Tees CCPP Examination – Issue Specific Hearing on Environmental Matters (13 June 2018) – follow up items on Air Quality

Introduction

Three items were raised by the Examiner ('ExA') which require follow up. These are:

**Figure 7.6**  
99.8<sup>th</sup> Percentile 1 Hour NO<sub>2</sub>, PC only, µg/m<sup>3</sup>

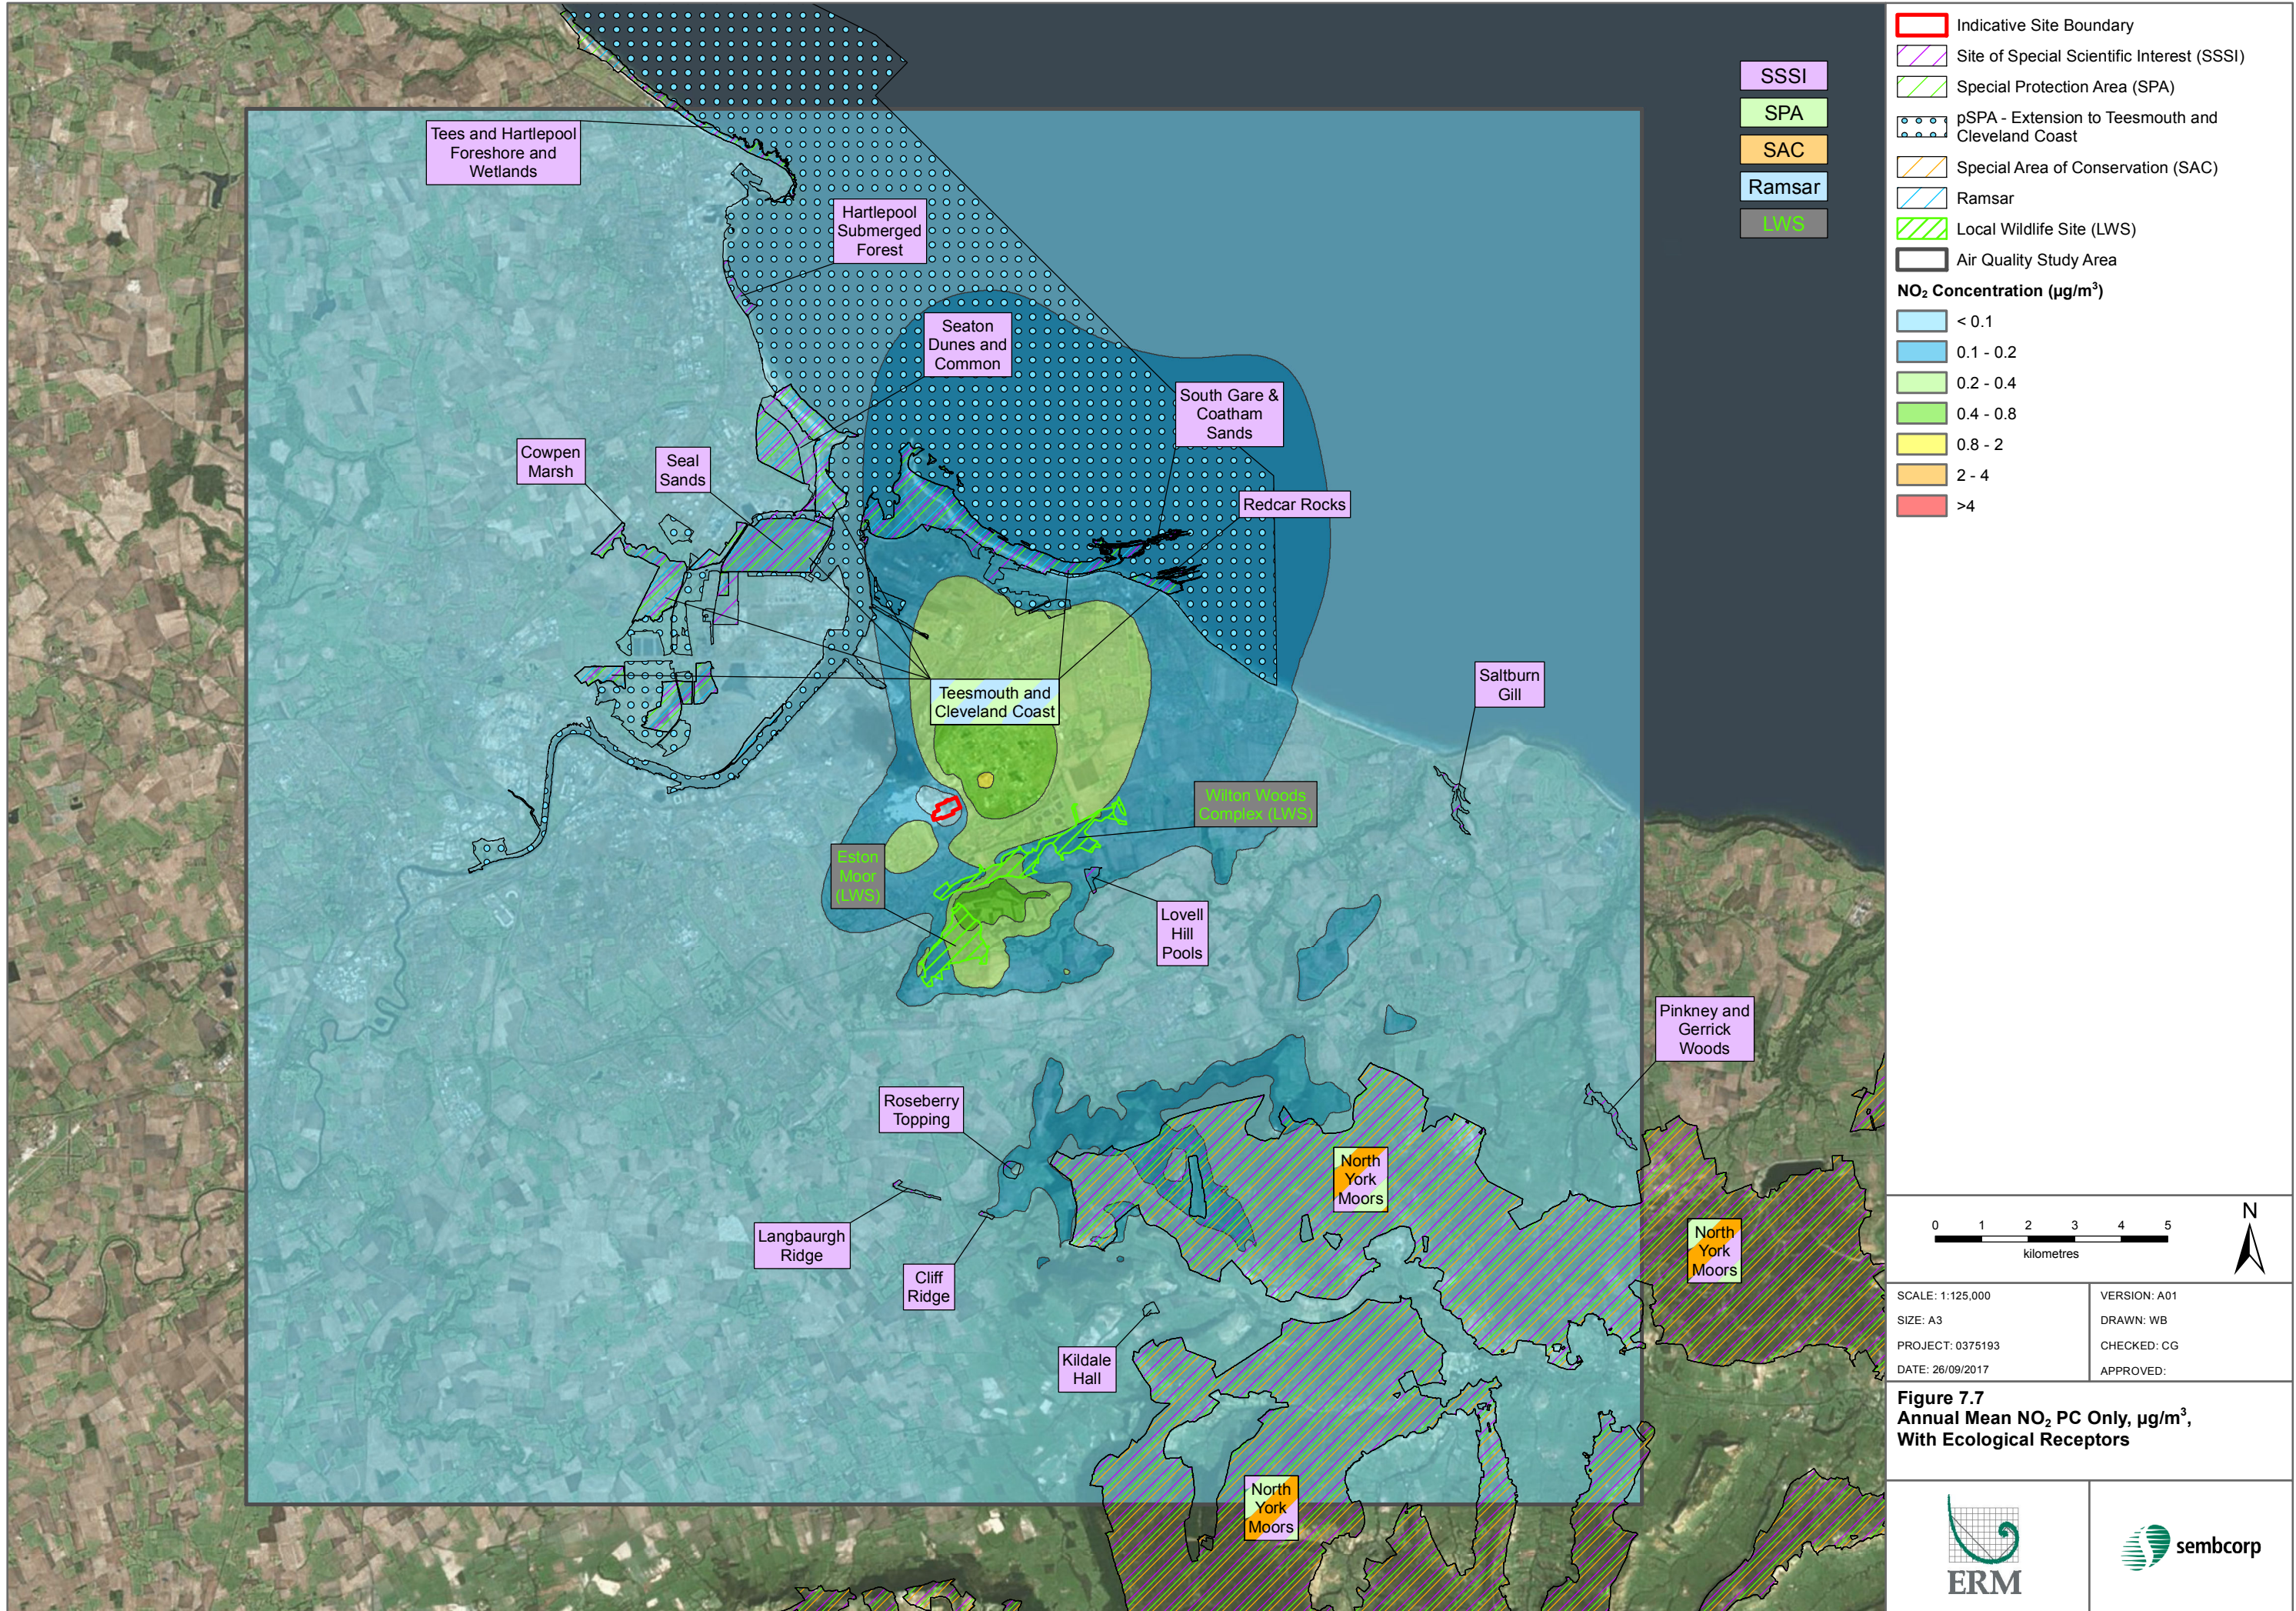
- identify the locations of the 'moderate' 1 hour NO₂ concentrations identified from the dispersion modelling;
- verify that sampling equipment is commercially available to undertake sampling from the centre of an 8 m diameter stack; and
- provide detailed results of the HRA (Habitats Regulations Assessment), as Excel files.

Locations of the 'moderate' 1 hour NO₂ concentrations

In the air quality impact assessment, a Moderate impact for the 1 hour NO₂ is defined as when the PC is between 20% and 50% of the air quality standard, irrespective of the baseline. The 1 hour NO₂ air quality standard is 200µg/m³, as the 19th highest 1 hour value. Therefore, Moderate impacts arise where the PC is between 40µg/m³ and 100µg/m³.

Figure 1 overleaf illustrates where the 1 hour NO₂ PC is greater than 40µg/m³. As illustrated, this is confined to two small areas on a steeply sloping wooded hillside. There are no sensitive human receptors in this location. **Figure 2** overleaf illustrates a zoomed in view of this small area. The buildings some distance to the south on **Figure 2**, are associated with communications towers in this location and are not residential properties.

The point of maximum impact for the 1 hour NO₂ is at OS Grid reference: 457726E, 518514N.
